GREATER LONDON AUTHORITY

Deadline 3 - Sheet 4: GLA commentary on other documents prepared by the Applicant for Deadline 2

Contains Ordnance Survey data © Crown copyright and database right [2018]
 Based on Babcock/EDF plan - RRRL Cable Route Landowners - 2-01-2010 - Drawing NO. Cable Route Plan
 © Crown copyright and database rights [2018] Ordnance Survey 0100031673

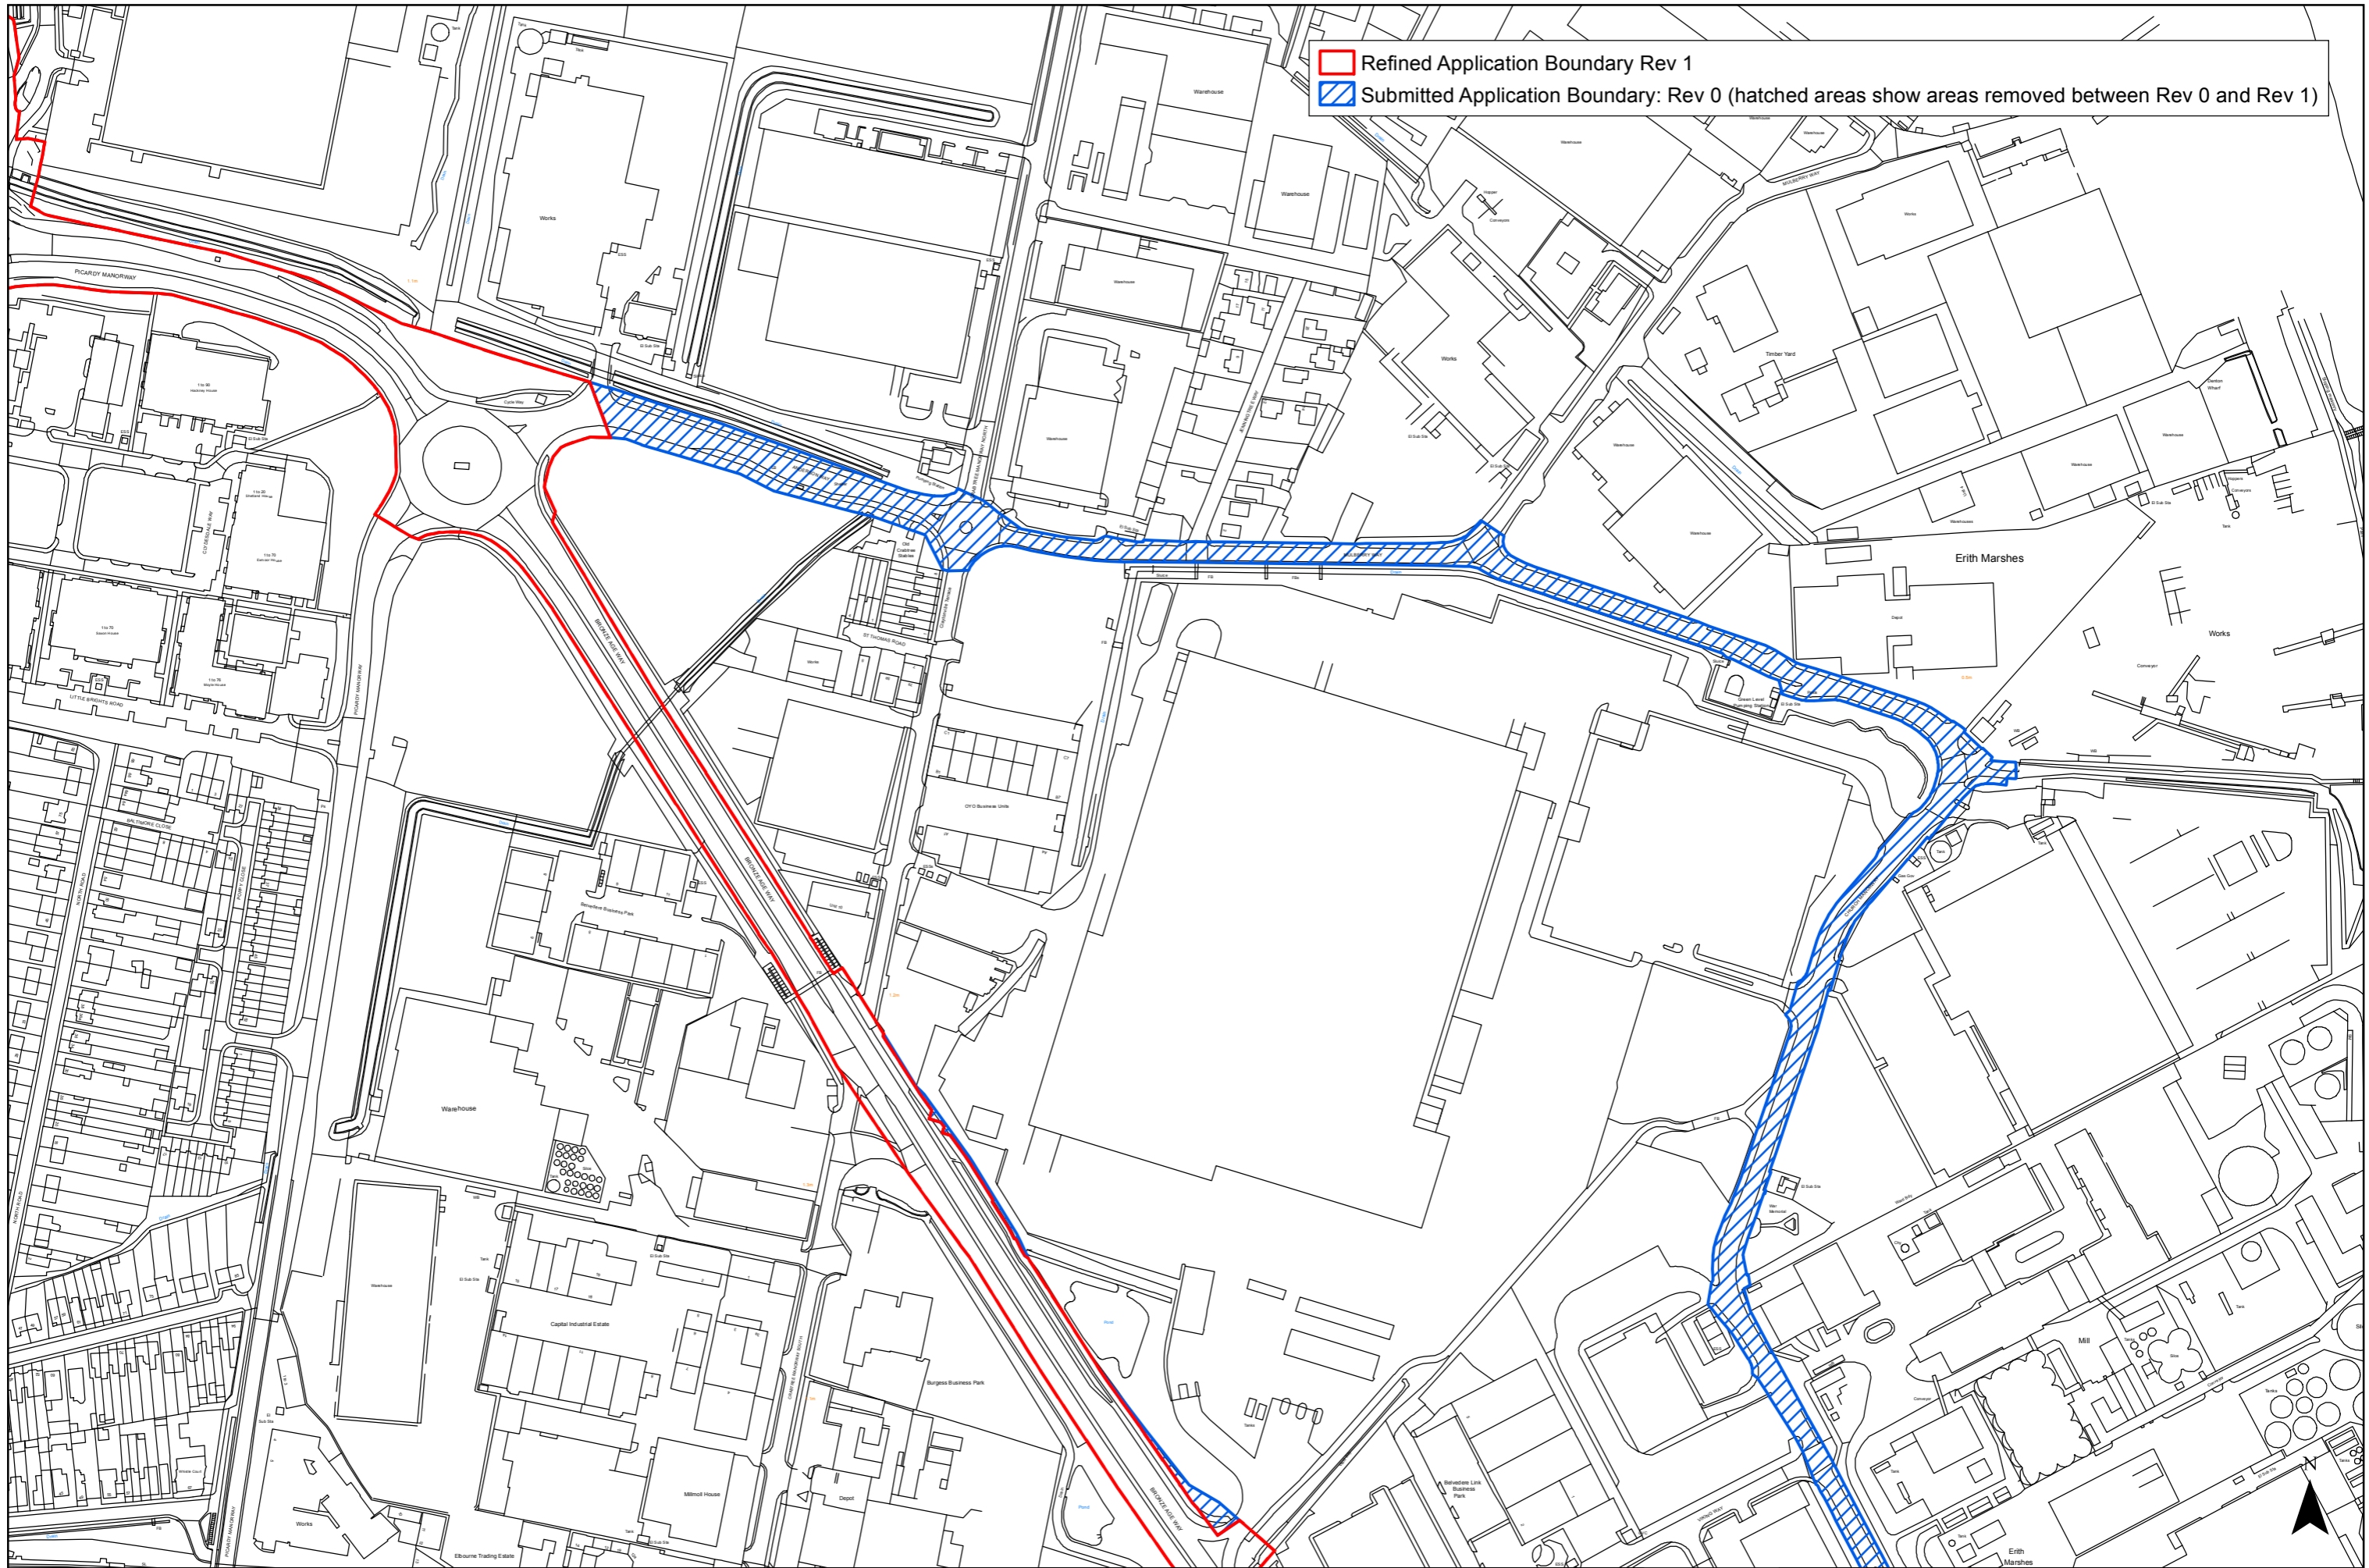
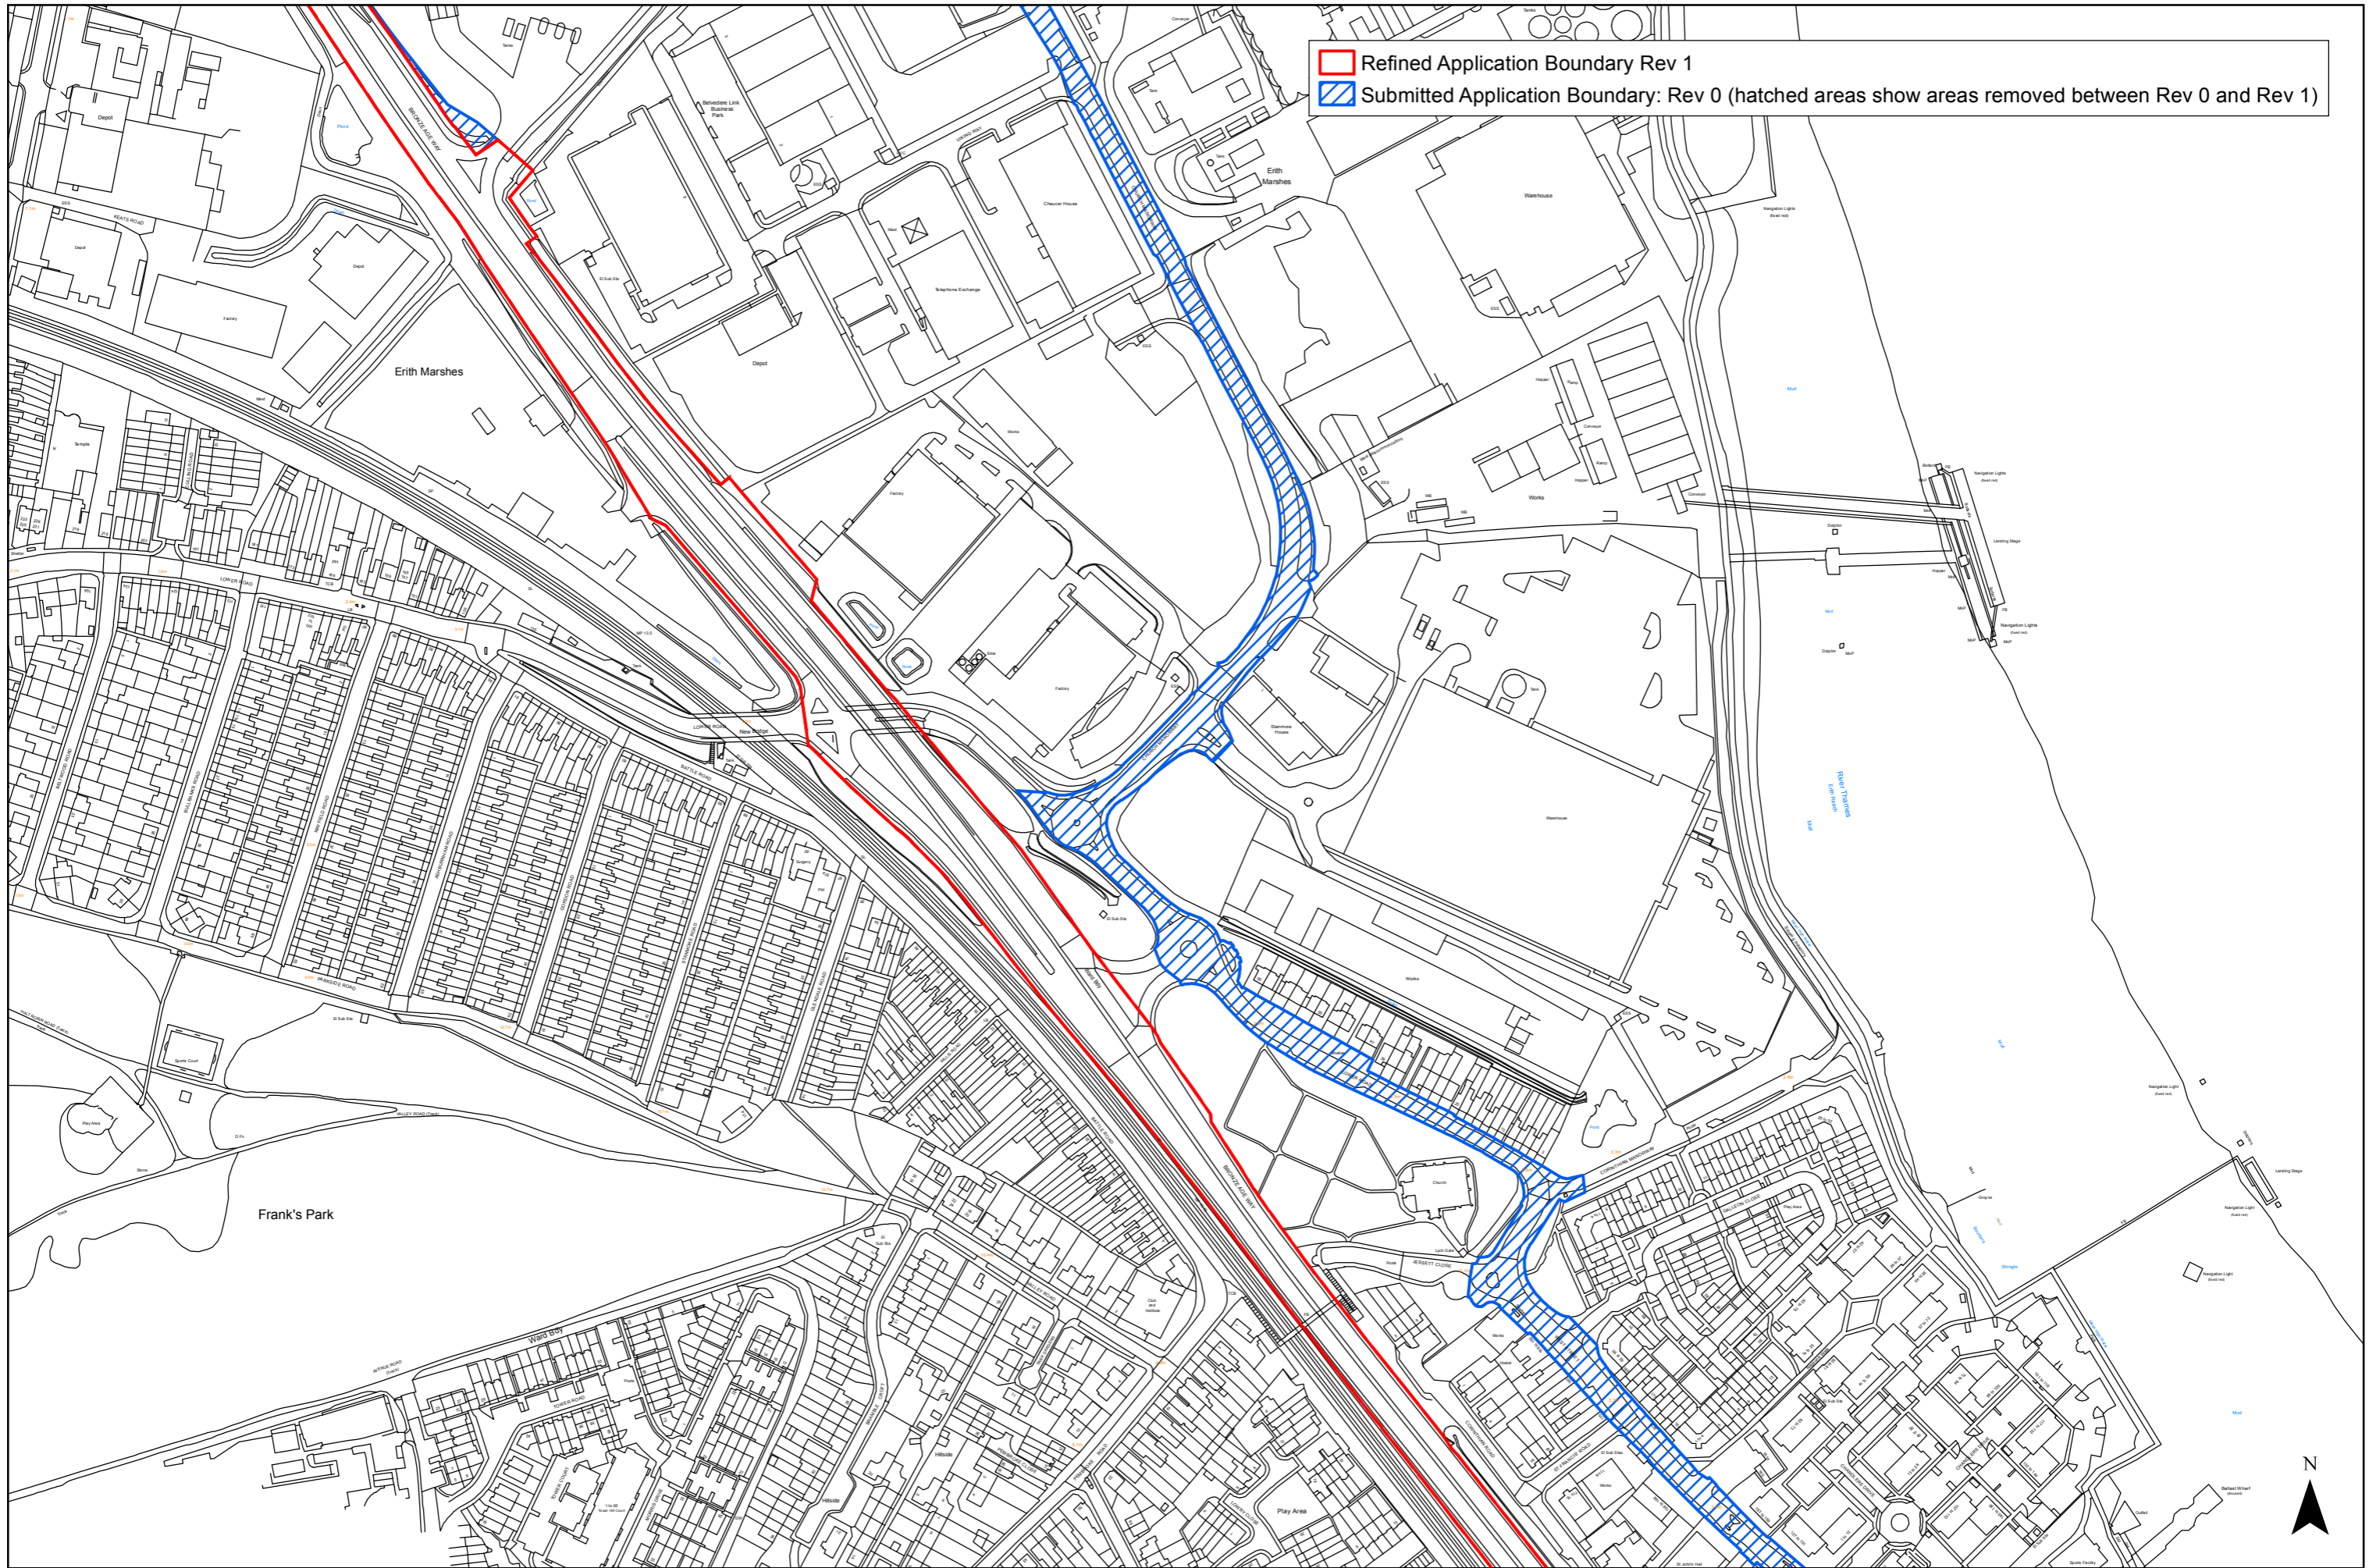
8.02.07 Electrical Connection Progress Report		
Connection route now selected	Additional assessment to determine quantifiable impacts of the Electrical Connection	The Applicant has set out the selected Electrical Connection route, which mostly follows the Strategic Road Network between the REP site and the Littlebrook Power Station. This route is expected to have a lesser impact on buses than the alternative route shown at the time of the submission of the application, however several bus routes will still be affected by the construction activities. This is set out visually in the figure below:

Item	Issue / action	GLA/TFL response
	<p>construction on buses.</p>	 <p>The map displays the River Thames flowing through the Bexley Heath area. A prominent yellow line, representing the 'ELECTRICAL CONNECTION', runs north-south through the center of the map. A network of red lines, representing 'BUS ROUTES', is overlaid on the map, showing various paths that cross the yellow line at several points. Key locations labeled include Bexley Heath, Erith, Crayford Marshes, and Rainham Marshes. A legend at the bottom of the map area identifies the yellow line as 'ELECTRICAL CONNECTION' and the red lines as 'BUS ROUTES'.</p> <p>The figure above shows that bus routes are expected to cross over the Electrical Connection route at several points via junctions and some bus routes would still run along the Electrical Connection</p>

Item	Issue / action	GLA/TFL response
		route. The impact of construction on these routes should be fully assessed by the applicant so that TFL and bus operating companies are able to propose mitigation based on the likely level of delay to the bus routes.
